OUT13/12940

23 MAY 2013

**Maules Creek Coal Project (10\_0138 Mod 1)  
Response to exhibition of Environmental Assessment**

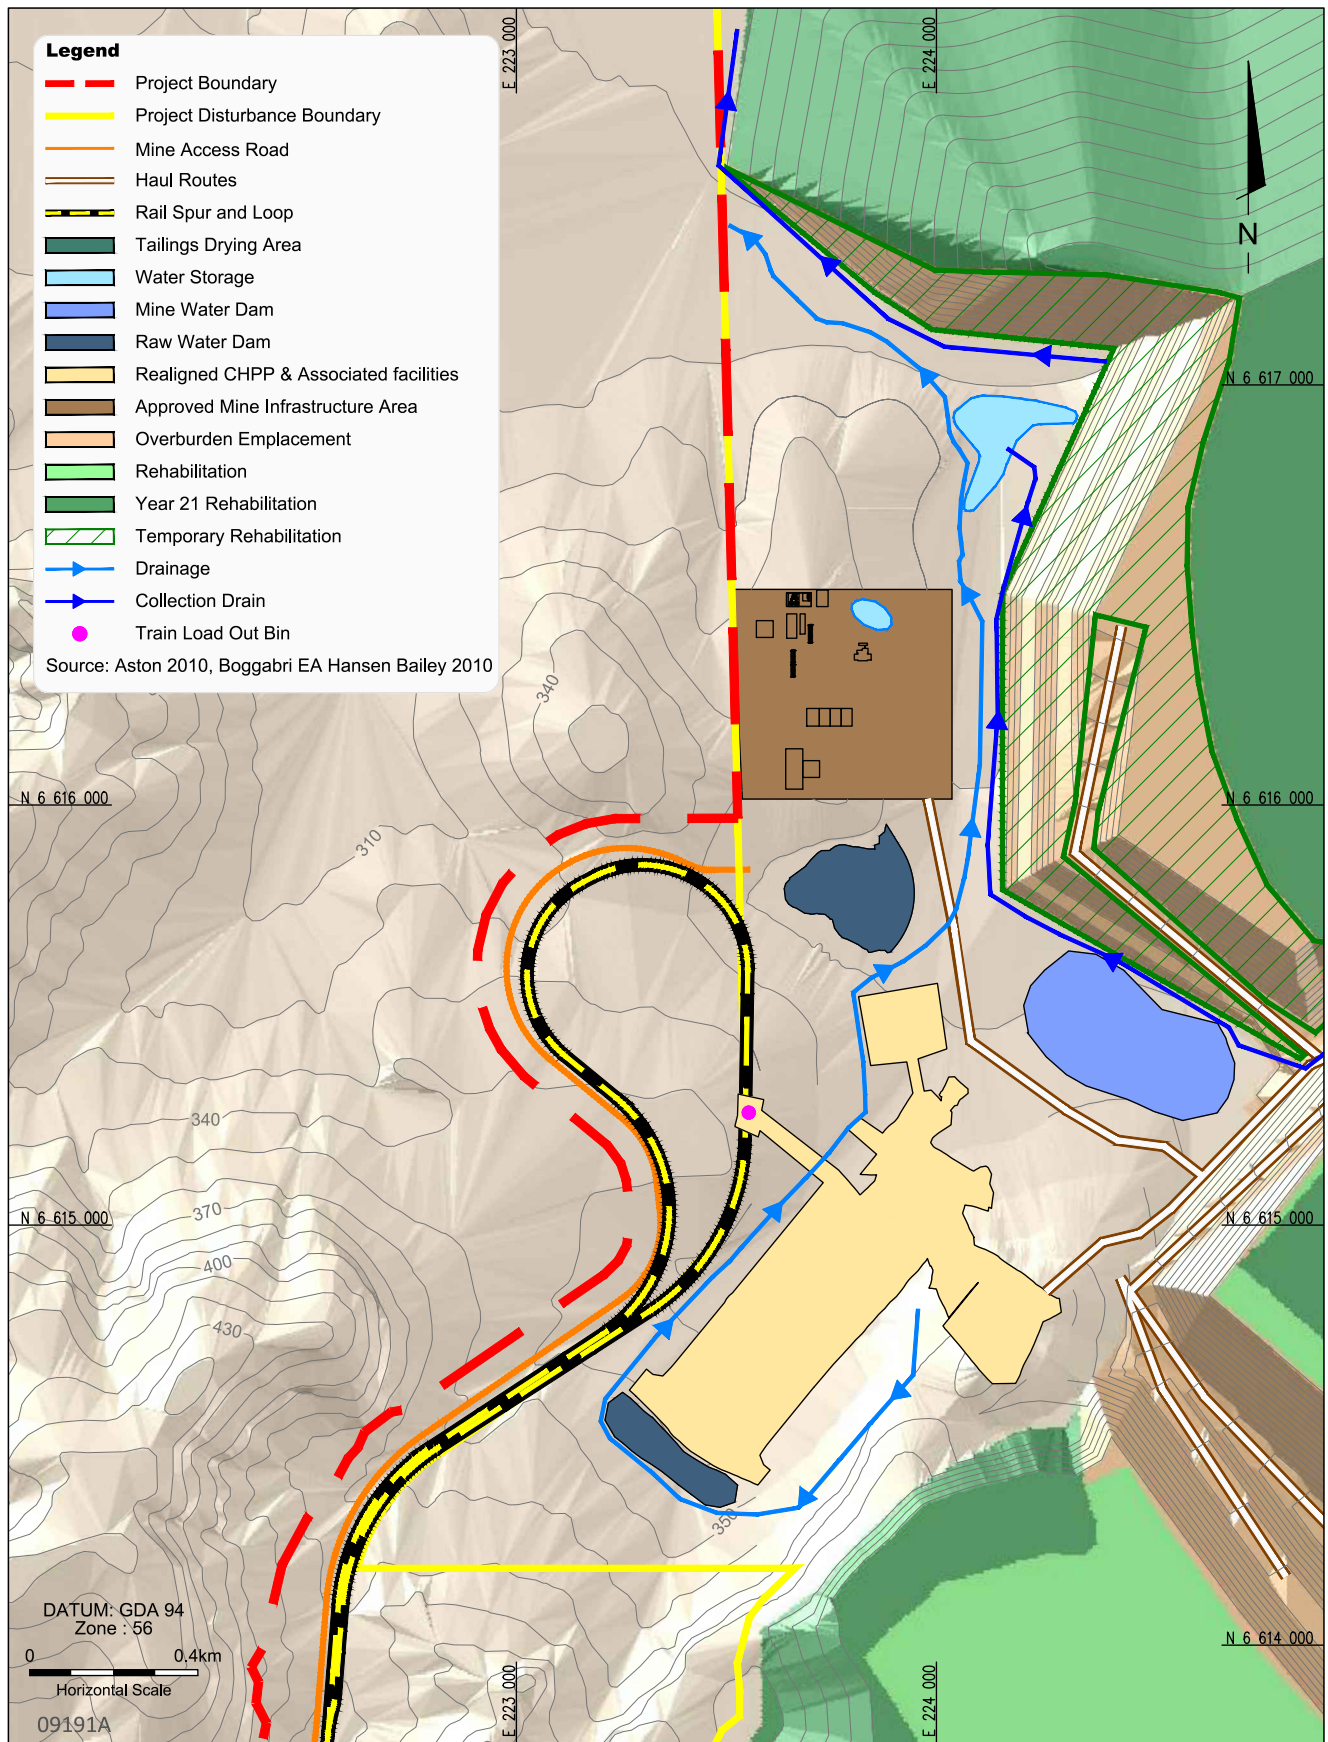
- The report did not contain the original approved alignment for the transmission line and switching station and infrastructure for the Coal Handling and Preparation Plant (CHPP) from the original Environmental Assessment for Maules Creek Coal Project. This made it difficult to determine exactly what changes were proposed from the approved layout.
- It is unclear in the report if the transmission line and switching station will impact on watercourses or drainage lines within the site. Whilst projects approved under the repealed Part 3A of the *Environmental Planning and Assessment Act 1979* do not require a separate Controlled Activity Approval under the *Water Management Act 2000*, works within riparian areas should be consistent with the Office of Water's 'Guidelines for Controlled Activities'.

- The modification report outlines the realignment of the CHPP will result in some minor changes in catchment for water collected for use within the water management system. The Office of Water recently provided comment on the Water Management Plan for the Maules Creek Coal Project. The Office of Water understands an updated site water balance, reflecting the changes to the layout of the CHPP were incorporated into the Water Management Plan.
- It is important appropriate Erosion and Sediment Control measures are implemented during the construction and operation phase, to prevent contamination to both groundwater and surface water sources.
